## Exhibit 22 - Page 2 of 6

# Summary of Comments on 1912-047-SUB1-PLANS\_review.pdf

FIGURE 2
SITE AND EXPLORATION PLAN
COSON RESIDENCE
7709 MERCER WAY
MERCER ISLAND, WASHINGTON

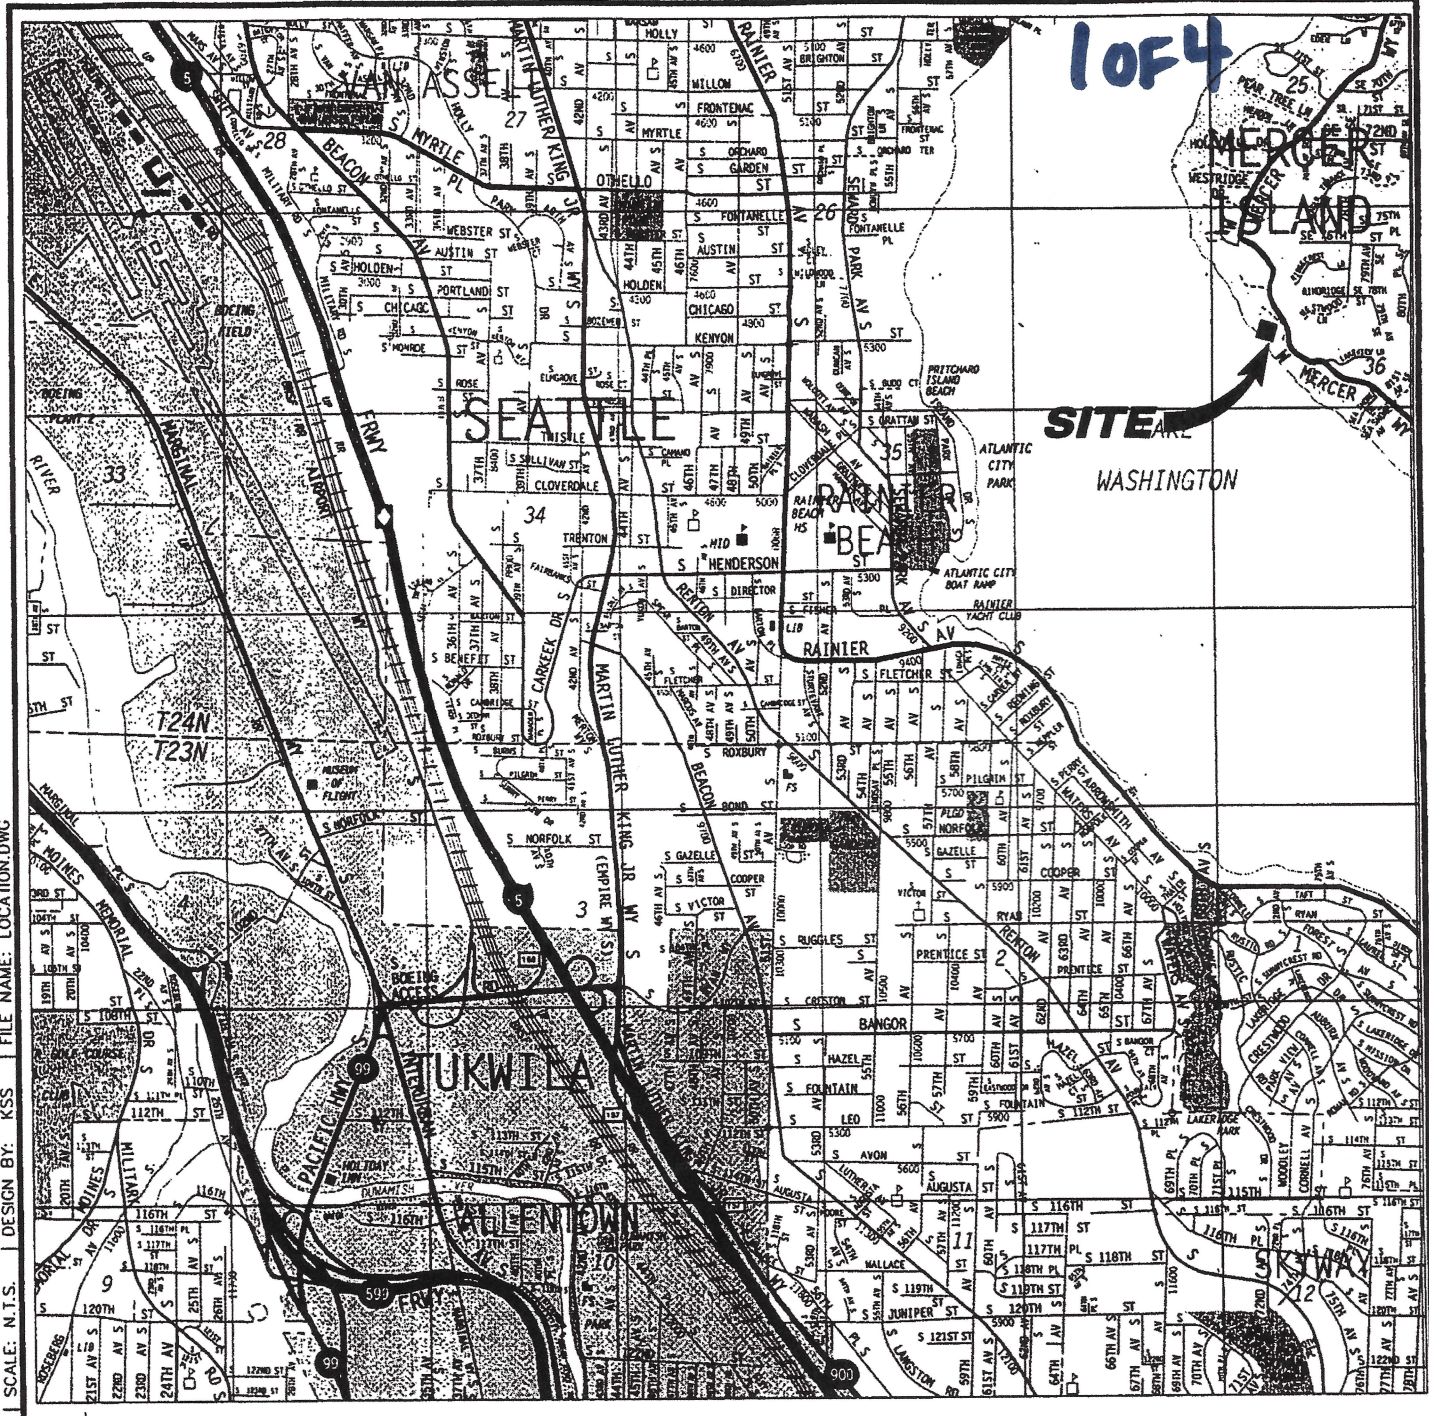
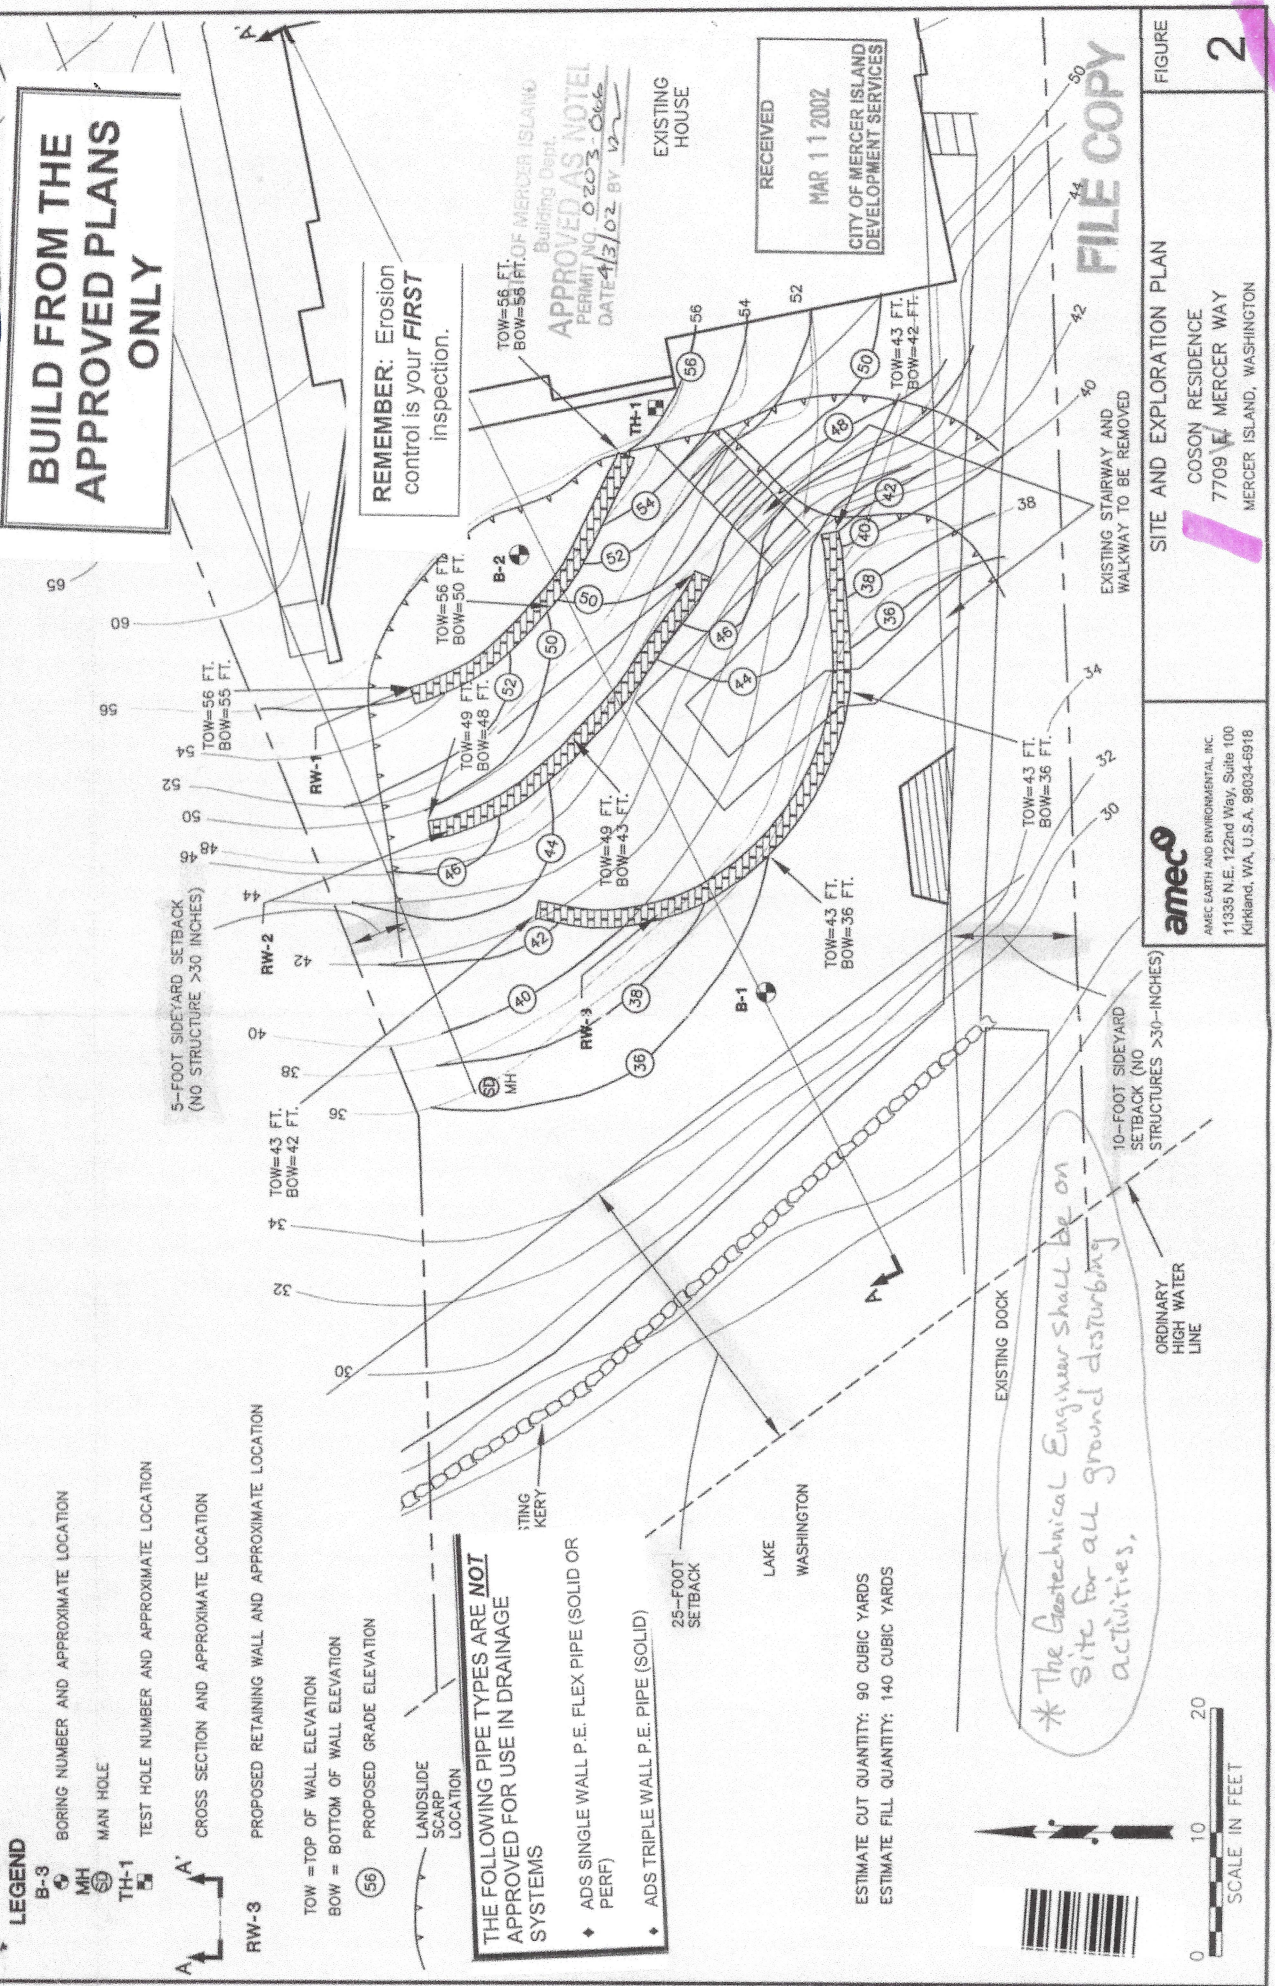
Page: 1			
Number: 1	Author: Building Review (paul.skidmore@mercergov.org)	Subject: Comment #1	Date: 12/30/2019 5:47:53 PM
	vable permanent backslope, per 2002 geotechnica vpical for colluvium soil and shall be confirmed by		1V, and recommended at
Number: 2 -08'00'	Author: Building Review (paul.skidmore@mercergov.org)	Subject: Comment #1	Date: 12/30/2019 4:34:21 PM
Please note. Th	ne drawings are incomplete and a full building plar	n review could not be per	formed. The following
correction items	s are general in nature and are not intended to co	mprise a comprehensive	plan review. Additional
correction items	s are likely during the next correction cycle.		
Number: 3	Author: Planning Review (nicole.gaudette@mercergov.org	) Subject: Sticky Note	Date: 1/2/2020 11:41:00 AM -08'00
engineering letters	building permit for the timber wall that was removed for the included with this application indicate that a timber retaining for in 2002 indicates that a rockery existed in the location of	ng wall was removed. However	r, permits SHL02-013 and 0203-066

forming because structures are not allowed within 25-feet o all being removed must be provided to prove that the wall is		rk of the lake. The permit(s) for the
Number: 4 -08'00'	Author: Building Review (paul.skidmore@mercergov.org)	Subject: Comment #1	Date: 12/30/2019 5:47:14 PM
Provide dimens the existing bul	ions locating nearest distance of new rockery fror khead?	n existing bulkhead. Will	new retaining wall surcharge
	Author: Geotechnical Peer Review (michele.lorilla@mercer og wall is surcharging the existing bulkhead, the geotechni on and repair recommendations, if necessary.		Date: 1/2/2020 9:59:00 AM -08'00' the impact on the bulkhead and
Number: 6 -08'00'	Author: Building Review (paul.skidmore@mercergov.org)	Subject: Comment #1	Date: 12/30/2019 5:16:27 PM
How does cond	rete path provide passive resistance? Note minim	num embedment depth of	f rockery. Indicate how vertical
cut in colluvium	is achieved. 2002 geotechnical report recommen	ds a maximum temporar	y cut of 1.5H:1V. Show extent

of excavation o	n the site plan. Note that the cut will be "chasing"	the existing slope up the	hill.
Number: 7 -08'00'	Author: Building Review (paul.skidmore@mercergov.org)	Subject: Comment #1	Date: 12/30/2019 5:46:27 PM
The geotechnic these trees on t	al engineer letter dated 2018 indicates 70 cypress the site plan. Note: it is not appropriate to state th ew work must meet all current code requirements uired.	at the newer system is "r	nore suitable" than the
Number: 8 -08'00'	Author: Building Review (paul.skidmore@mercergov.org)	Subject: Comment #1	Date: 12/30/2019 5:23:28 PM
	ered design of rockery retaining wall, including all recommendations are not appropriate in critical a		e stability analysis for this

How many cubic yards of excavation are required (cut and fill) for the project?

Provide a survey by a signed and sealed by a Washington State licensed surveyor. Indicate on the drawing(s) all hardscape, structures, retaining walls, trees, etc. Locate and dimension all hardscape and structures.

Provide a legible topographical site plan.

CROSS SECTION A-A'

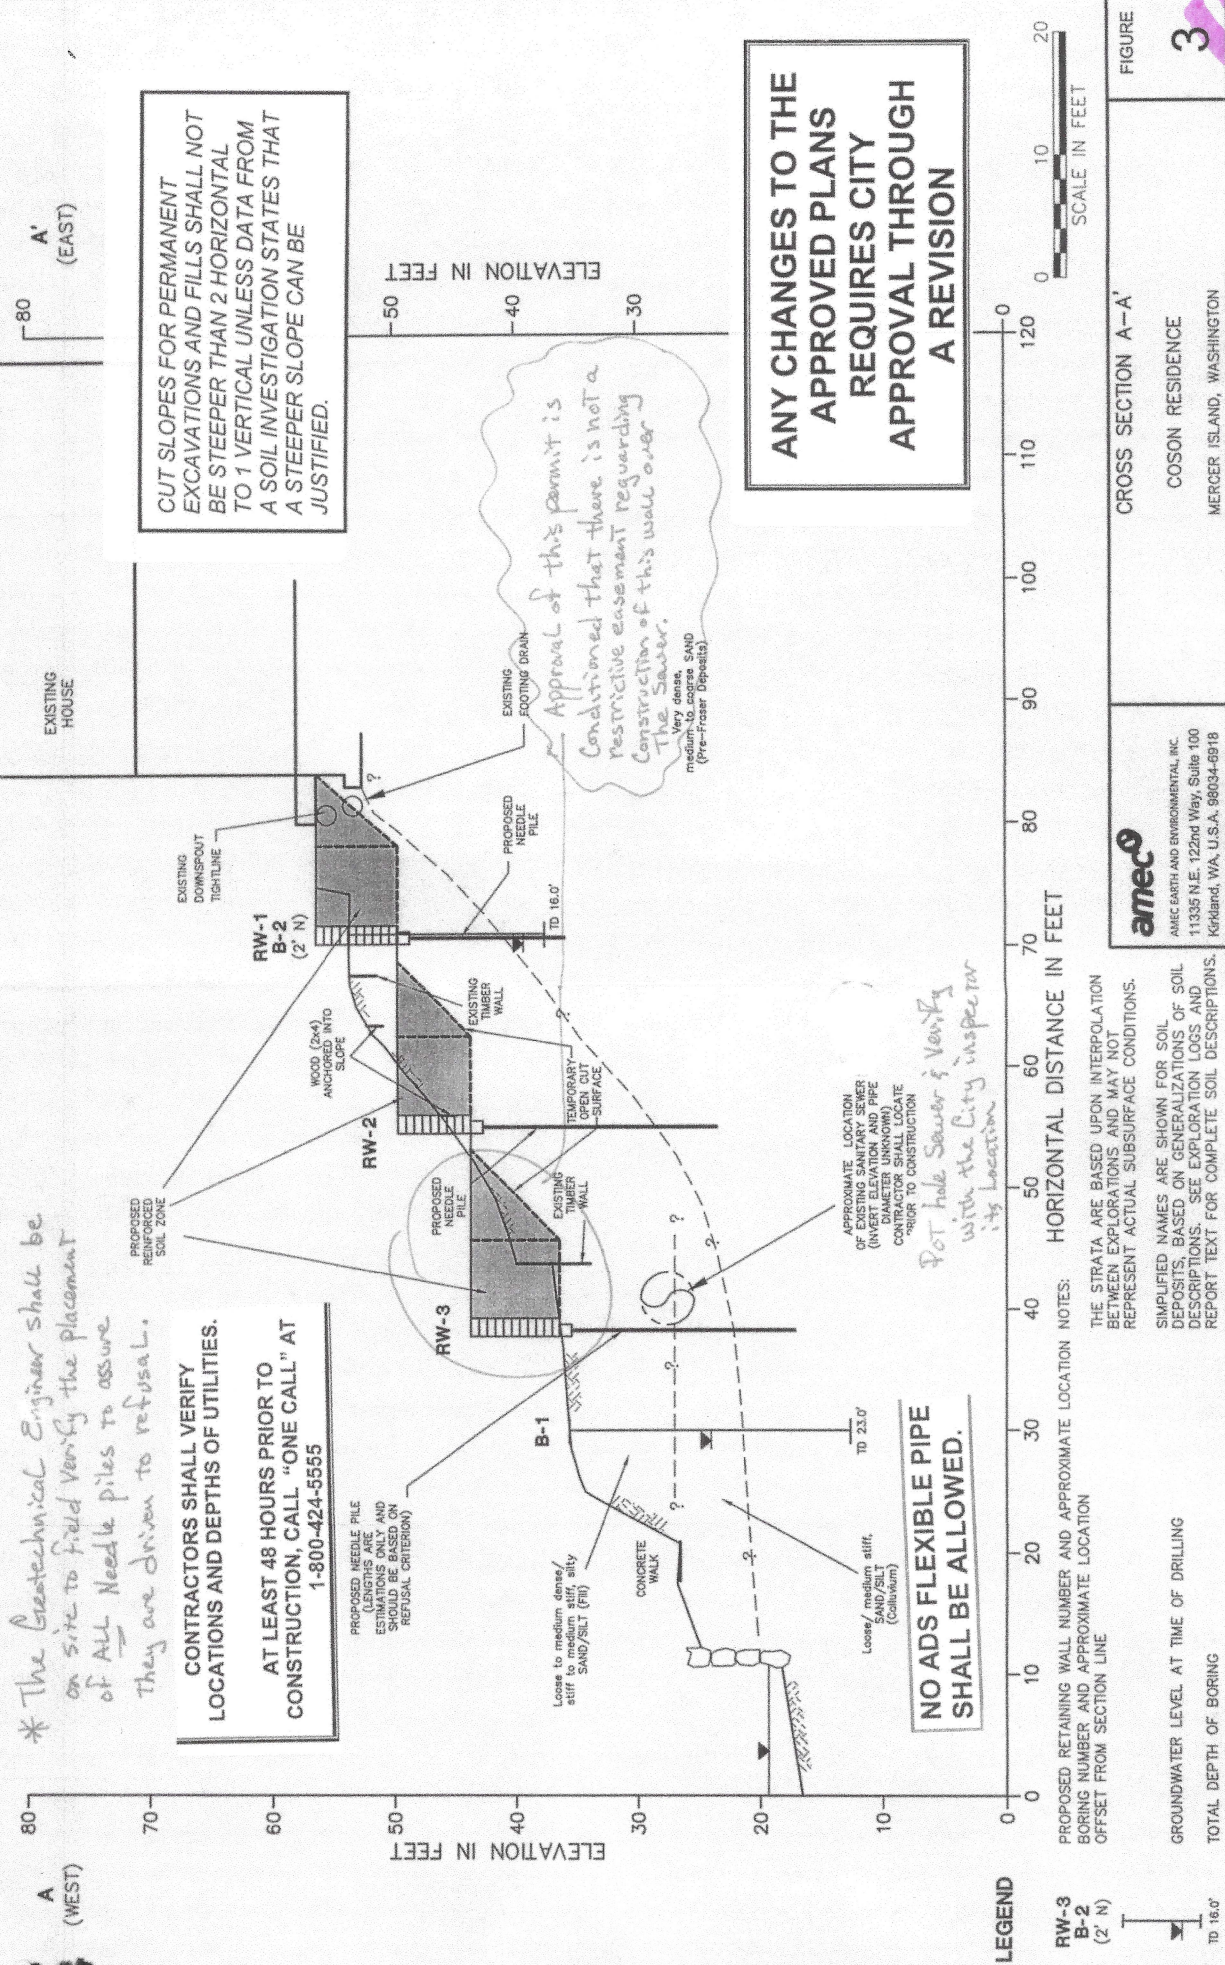
- Number: 2 Author: Geotechnical Peer Review (michele.lorilla@mercergov.org) Subject: Comment Date: 1/2/2020 10:00:53 AM -08'00' Geotechnical engineer to determine cause of wall failure and provide recommendations for stabilization and repair. New soil explorations will be required at the location of the wall to assess the wall failure as well as provide subsurface information for the stabilization and repair. Geotechnical engineer shall specifically address the appropriateness of wall type to retain loose soil conditions as identified in boring B-1 of the 2002 AMEC report if similar soil conditions are encountered in the new soil explorations. Wall design calculations shall be included in the resubmittal as well as stability analyses to verify the stability of the wall. Stability analyses should also assess impact of this lower wall on the stability of the existing features upslope of the wall.

- Mumber: 3 Author: Geotechnical Peer Review (michele.lorilla@mercergov.org) Subject: Comment Date: 1/2/2020 10:05:05 AM -08'00' Geotechnical engineer to assess potential undermining of existing timber wall due to lower wall failure and repair activities and provide recommendations for mitigation of impact to existing timber wall or repair recommendations as needed.
